EAST PRESTON PARISH COUNCIL

19th April 2017

Re: EP/41/17/PL, 4 Beechlands Cottages and land adjacent to 4 Beechlands Cottages, Beechlands Close, East Preston

JOB TITLE			
New house at Beachlands Close, East Preston			
CLIENT			
Dearden Homes			
DRAWING TITLE			
Proposed Plans and Elevations			
DATE	SCALE	DRAWN BY	CHECKED BY
Sept 2016		GIM	
JOB NO.	DRAWING NO.	REVISION	
1671	2.02	A

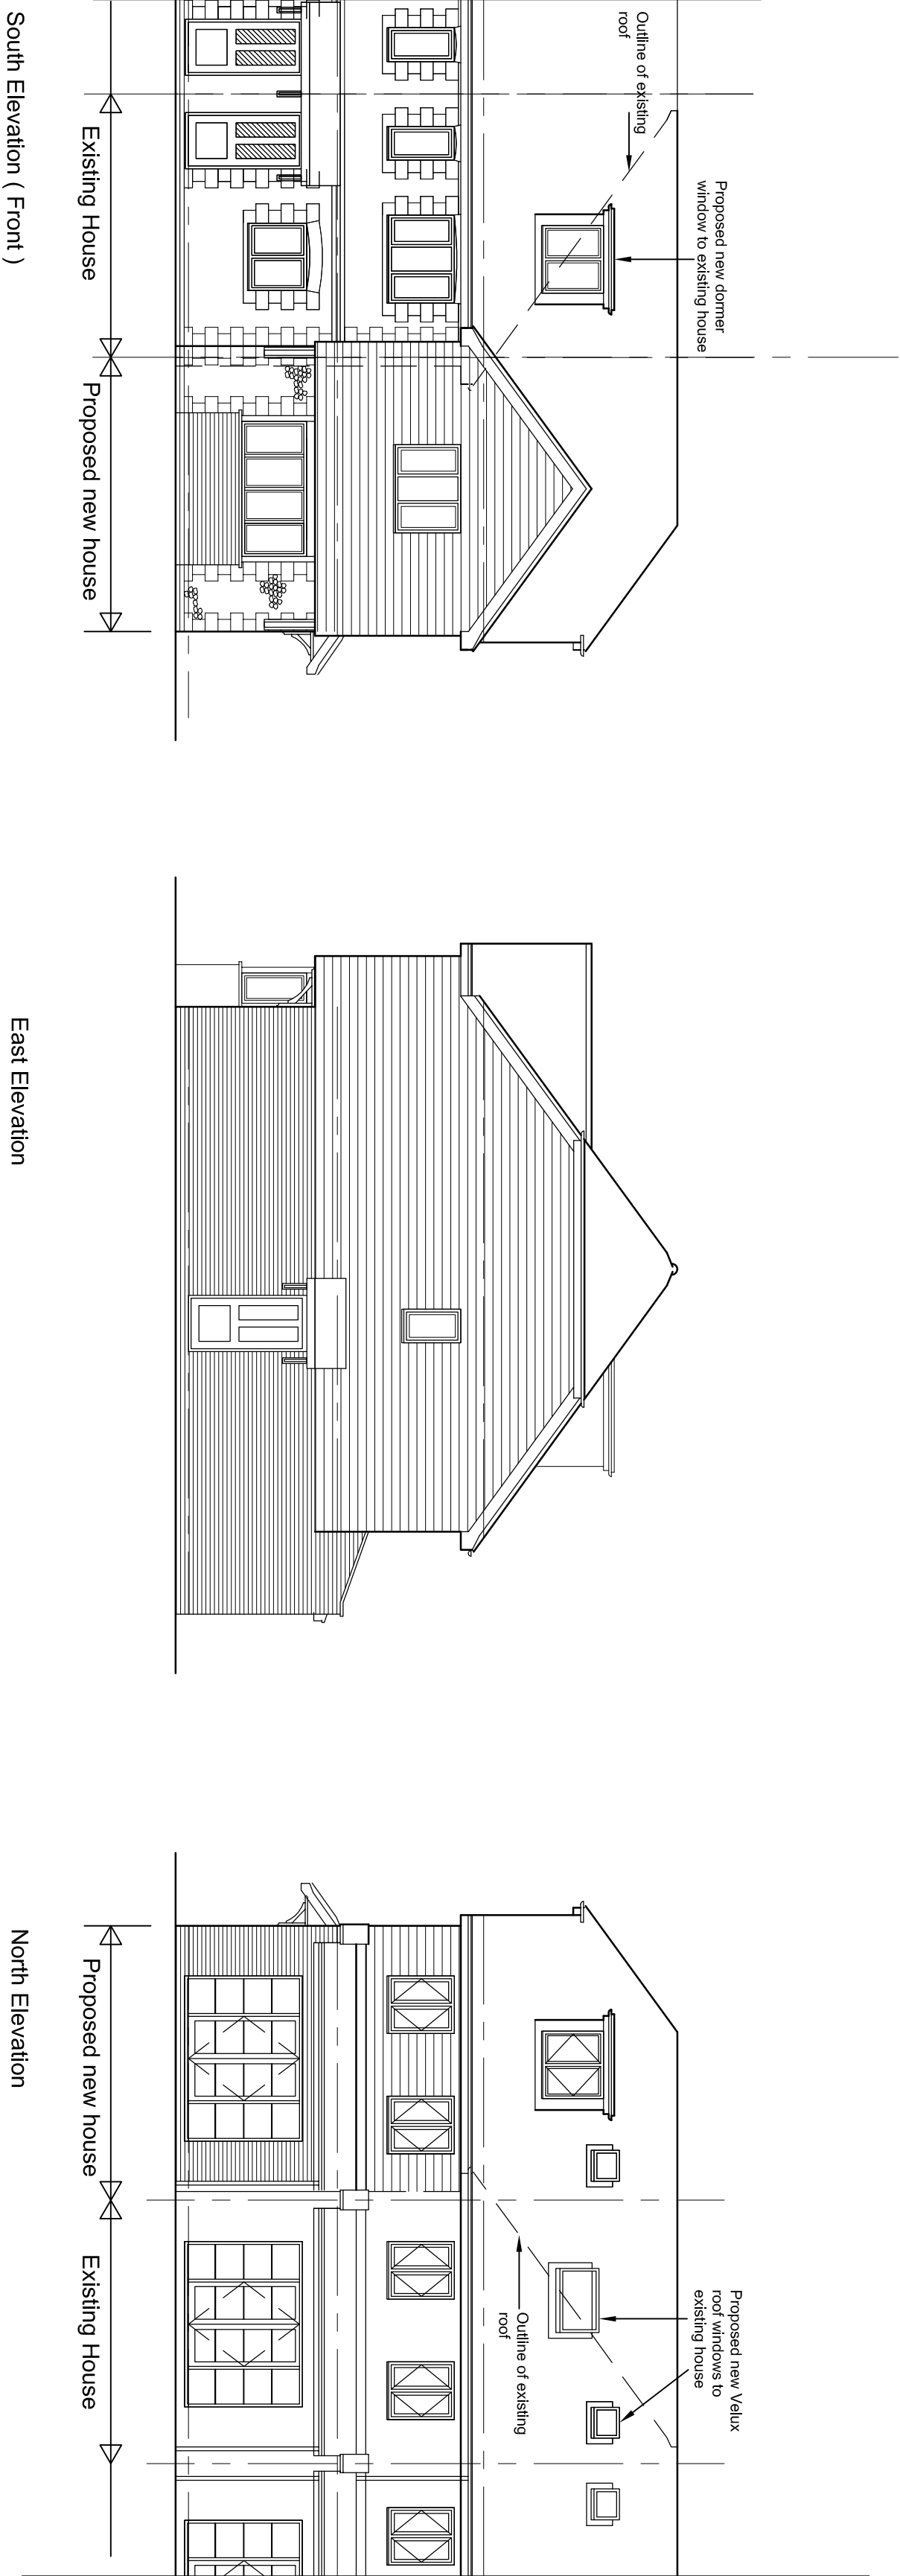
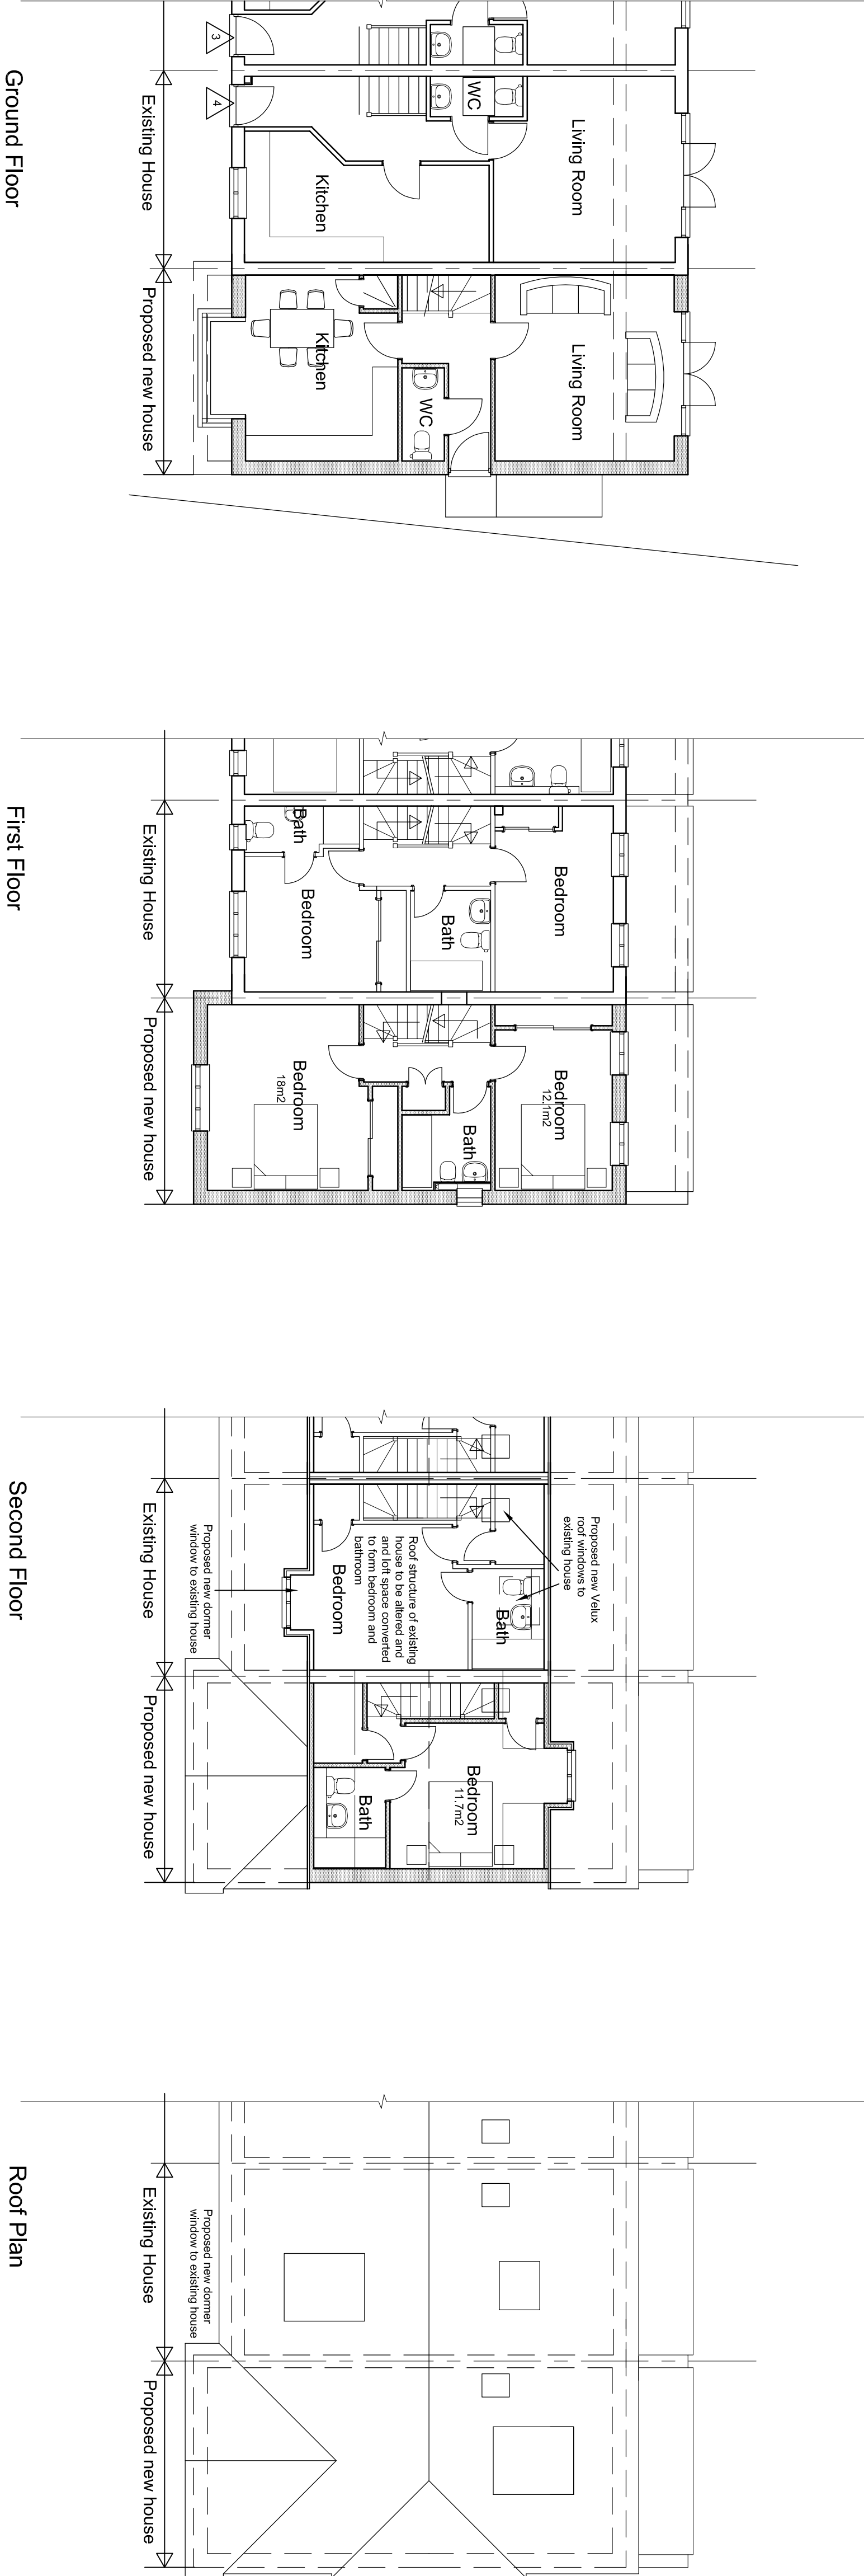
The proposed new property, added to the eastern end of the existing terrace of four, relatively new properties, will result in an unbalanced structure with the roofline treatment at the eastern end differing from that already existing at the western end. The new property will also be stepped in front of the existing terrace and building line. These factors would result in the new house looking like an obvious addition. The proposal will therefore conflict with the Arun Local Plan as the addition will not be visually integrated with the existing building which is a symmetrical design of four properties. The loft conversion to the existing eastern property will also upset the symmetry of the terrace.

The council does not favour the use of cladding within the village as it is not vernacular and furthermore believes the use of cladding in this property, as opposed to the flint work on the existing terrace of four properties, will leave the property looking out-of-keeping with the rest of the terrace. Furthermore, the property will also look out-of-keeping as it will not have an entrance door at the front. The council was further concerned about the narrow gap between the south-eastern corner of the property and the fence line – is it necessary for the property to come in front of the established building line of the existing four properties?

CLIENT			
Dearden Homes			
JOB TITLE			
New house at Beachlands Close, East Preston			
DRAWING TITLE			
Proposed Site Plan Block and Location Plans			
DATE	SCALE	DRAWN BY	GIM
Sept 2016		CHECKED BY	
JOB NO.	DRAWING NO.	REVISION	
1671	2.03	A

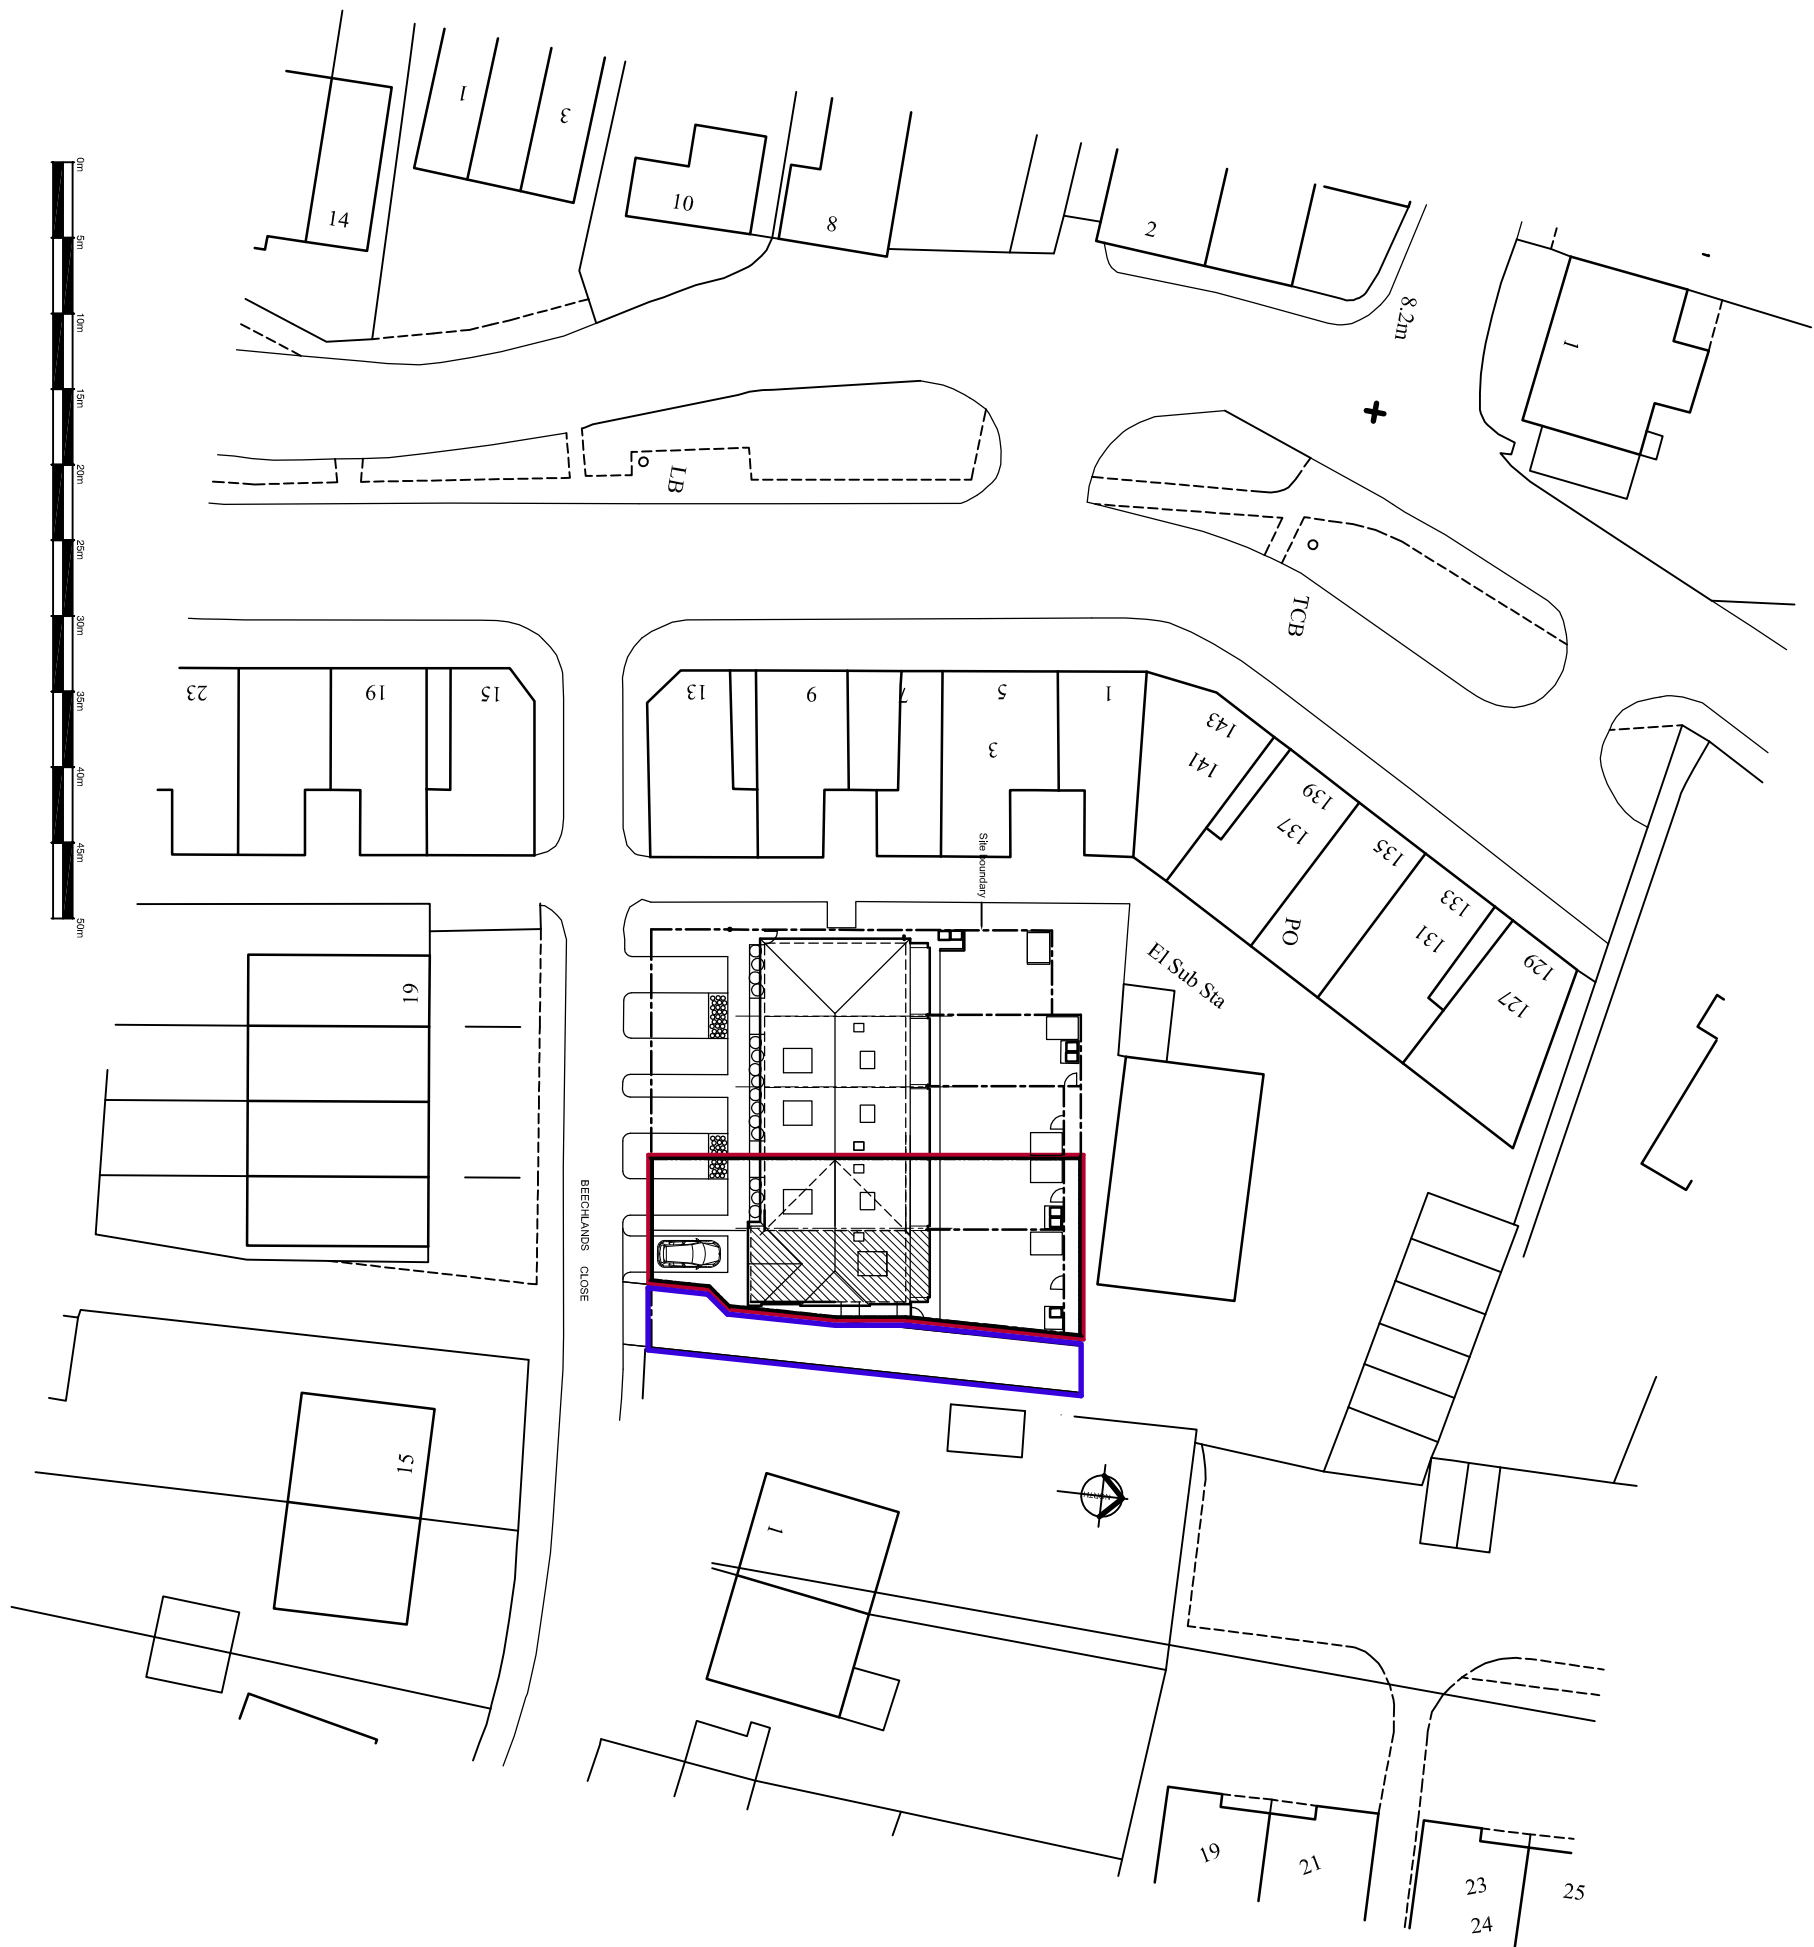
Although the council has seen the response from West Sussex County Council Highways it remains concerned the narrowing of the driveway to the land to the north of Beechlands Cottages will prevent large vehicles using the driveway to deliver goods to the rear of the convenience store in North Lane and this will lead to an increase in large-vehicle deliveries taking place in the service road to the immediate northwest of Beechlands Cottages. This is a narrow service road and large delivery vehicles already cause a certain amount of hassle there. Residents present at the committee's meeting said lorries already have some difficulties with the current width of the driveway.
